EPC STORMWATER REVIEW COMMENTS  
IN ORANGE BOXES WITH BLACK TEXT

### GRADING AND EROSION CONTROL PLAN JUDGE ORR ROAD RV PARK AND STORAGE EL PASO COUNTY, COLORADO

**JUDGE ORR ROAD RV PARK & STORAGE**  
**COLORADO SPRINGS, COLORADO**  
**DRAINAGE, GRADING & EROSION CONTROL COVER**

PCD PROJECT NO. PPR-16-040

**DRAINAGE, GRADING & EROSION CONTROL PLAN**

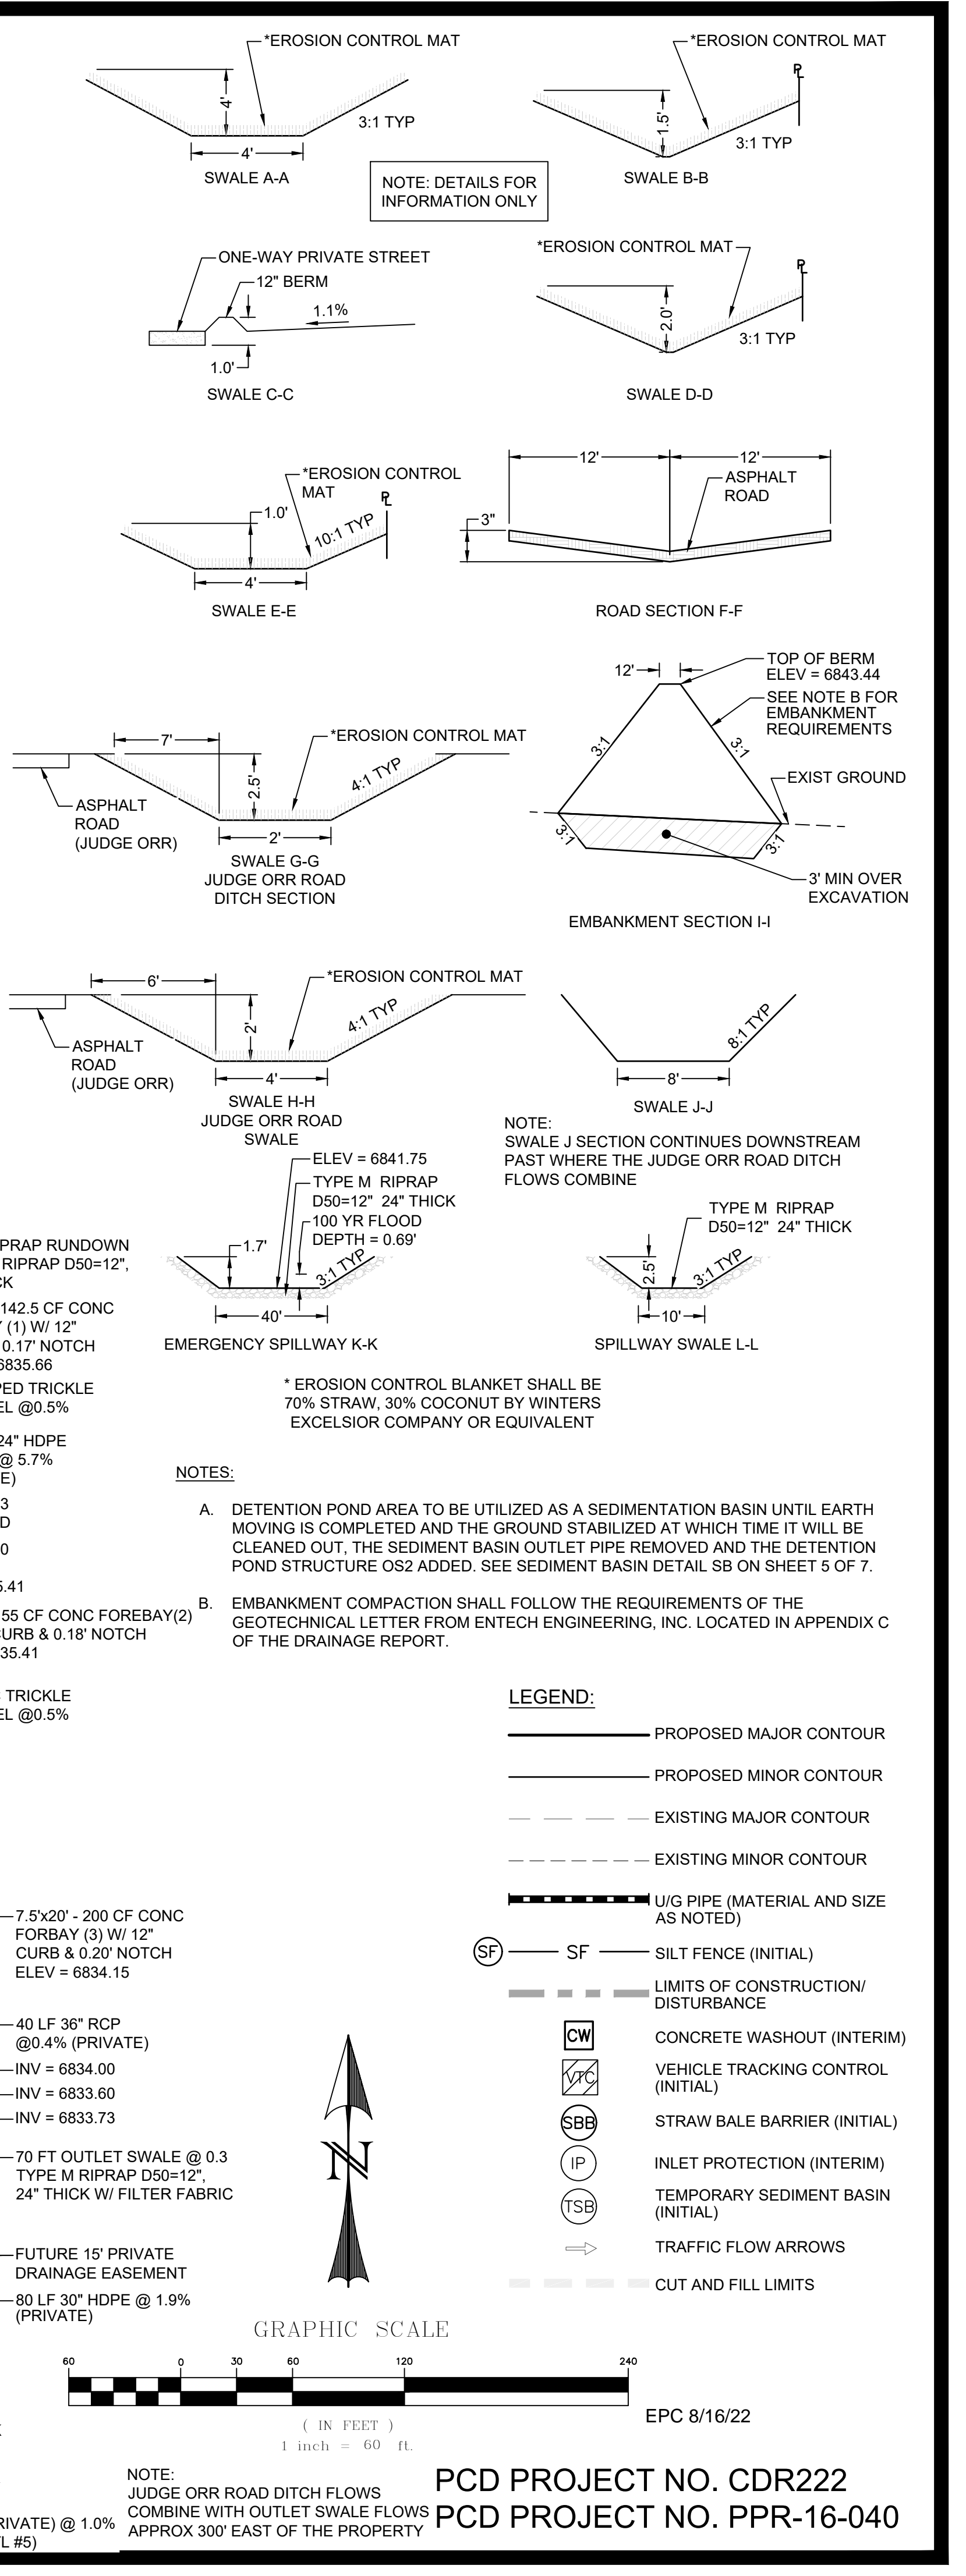
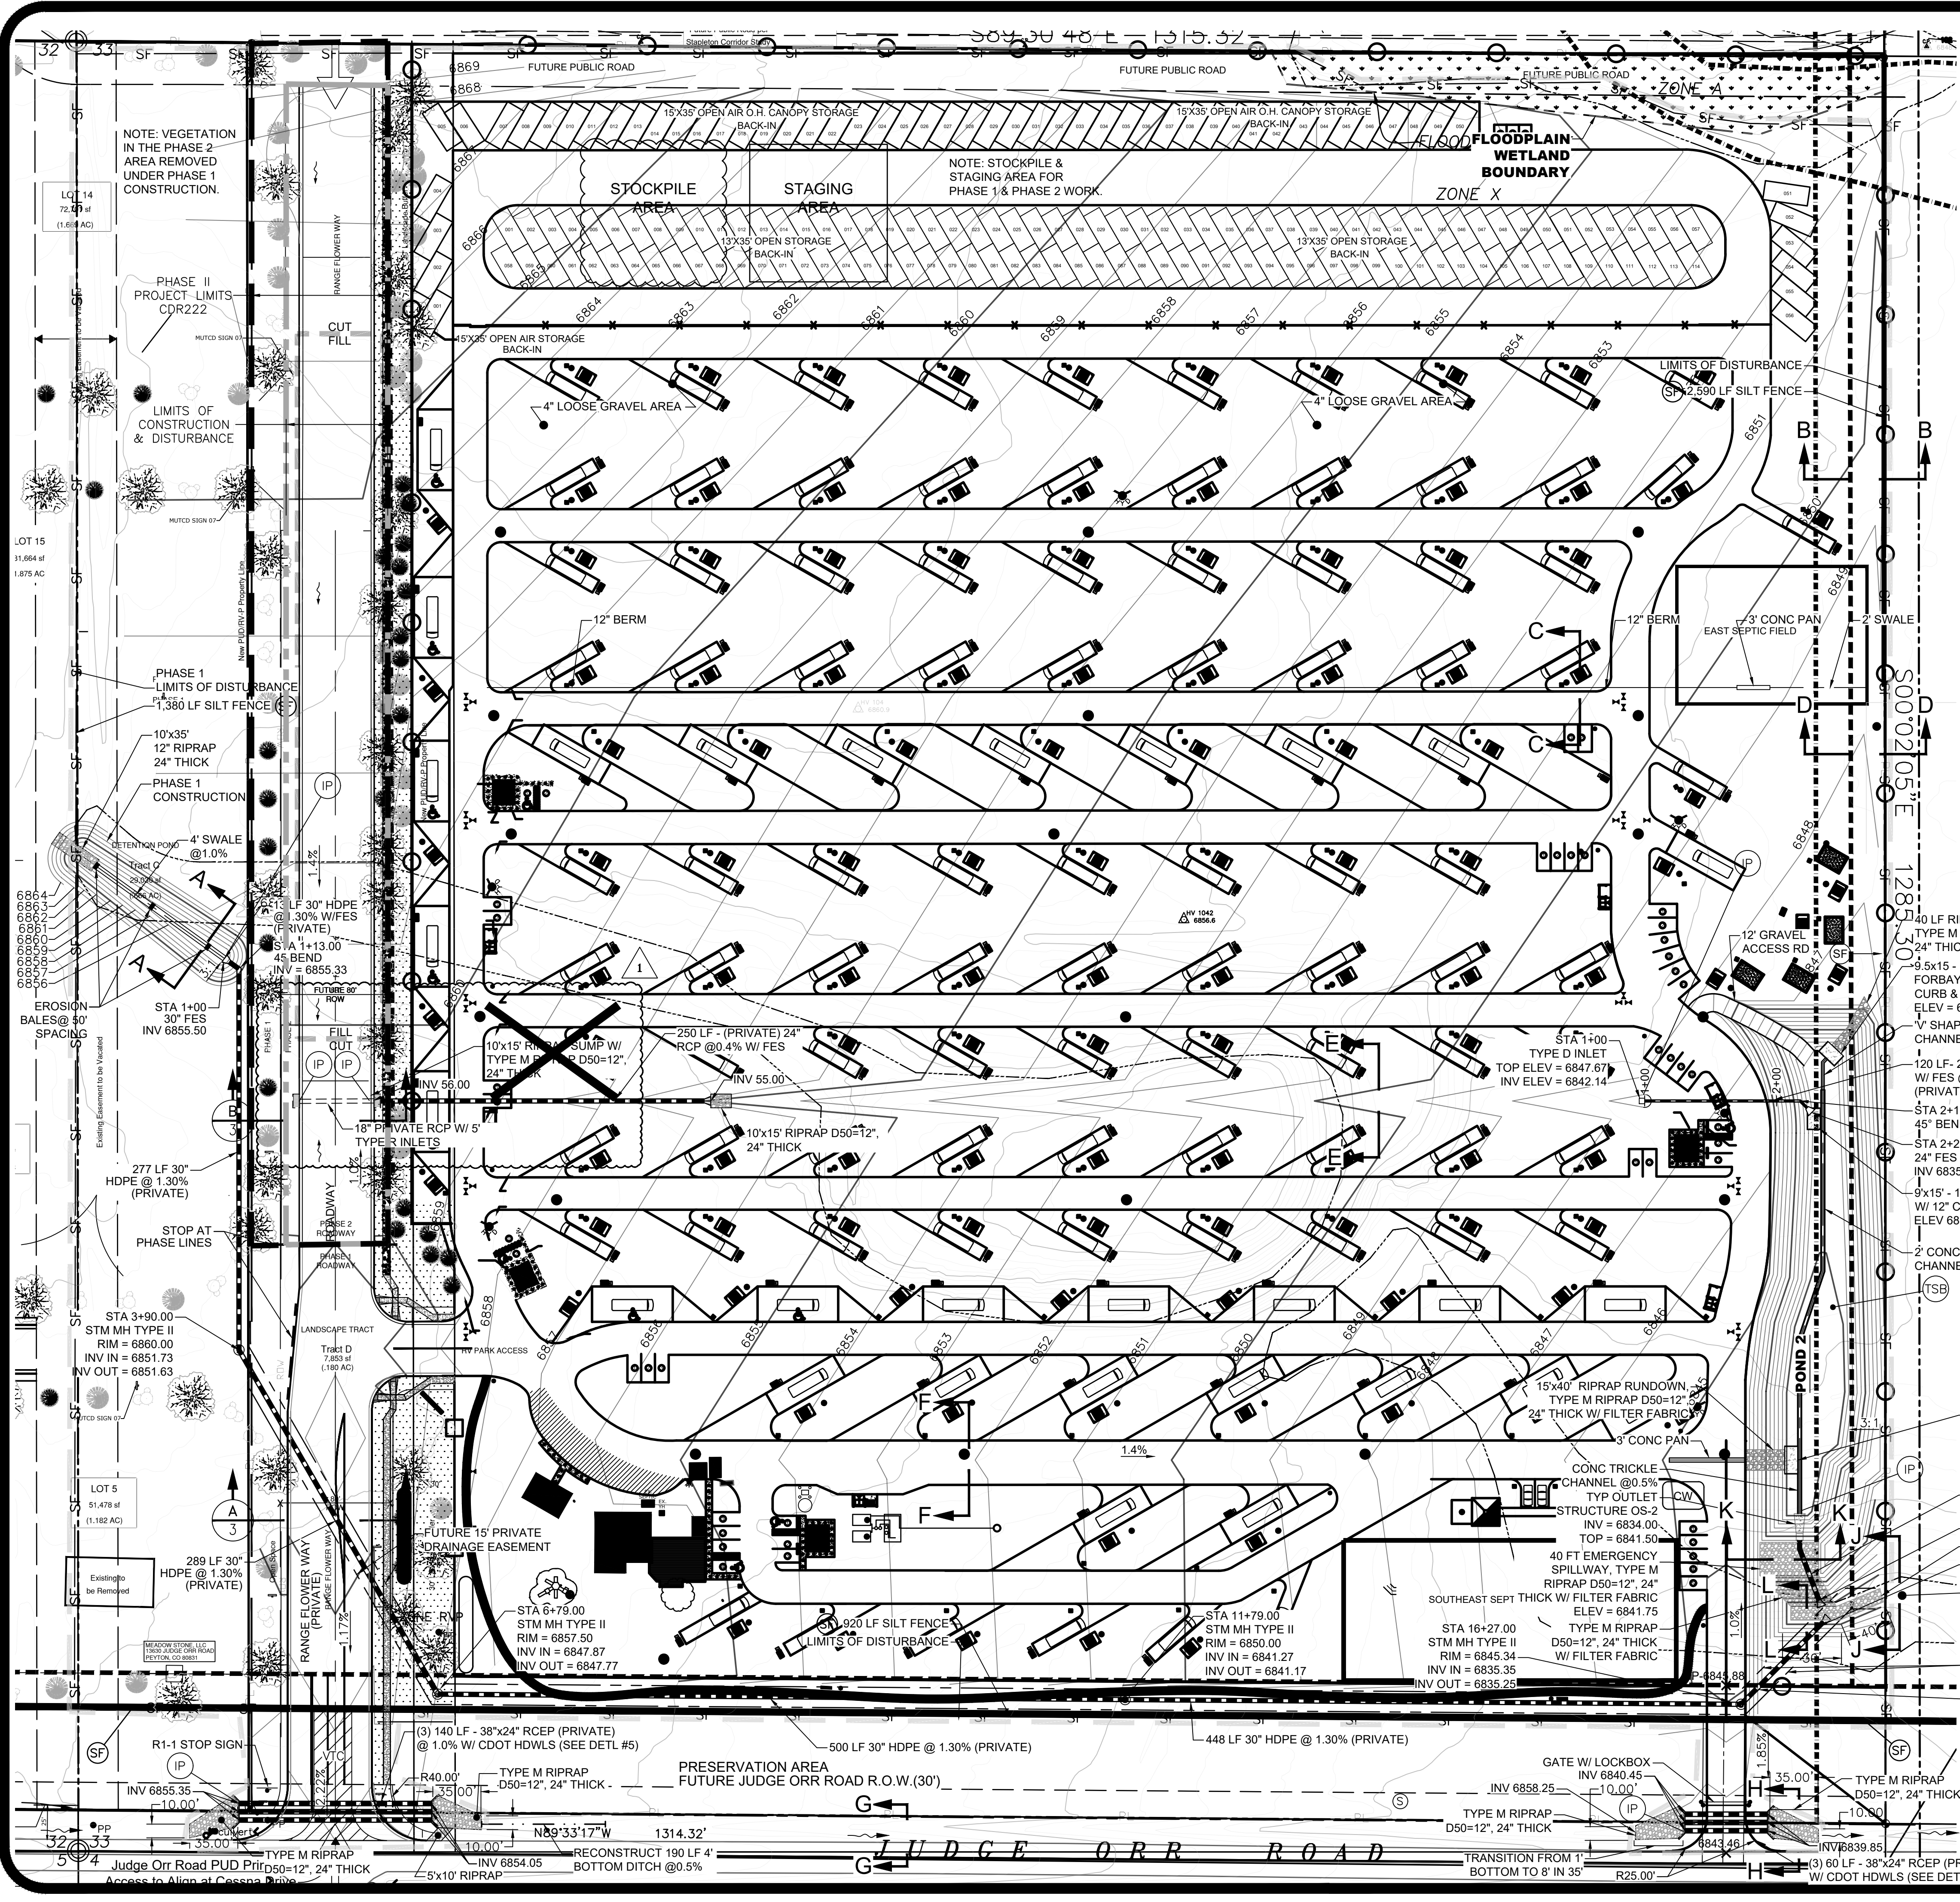
Only show area of proposed improvements as black and/or within a bubble/cloud. All other work should be "grayed-out" to show that is existing and/or not part of this submittal.

Same with BMPs and their callout bubbles, gray out all those not associated with CDR222

Please use the latest base drawing used in the CD's that does not show this traffic circle since the traffic circle is not on the site drawing.
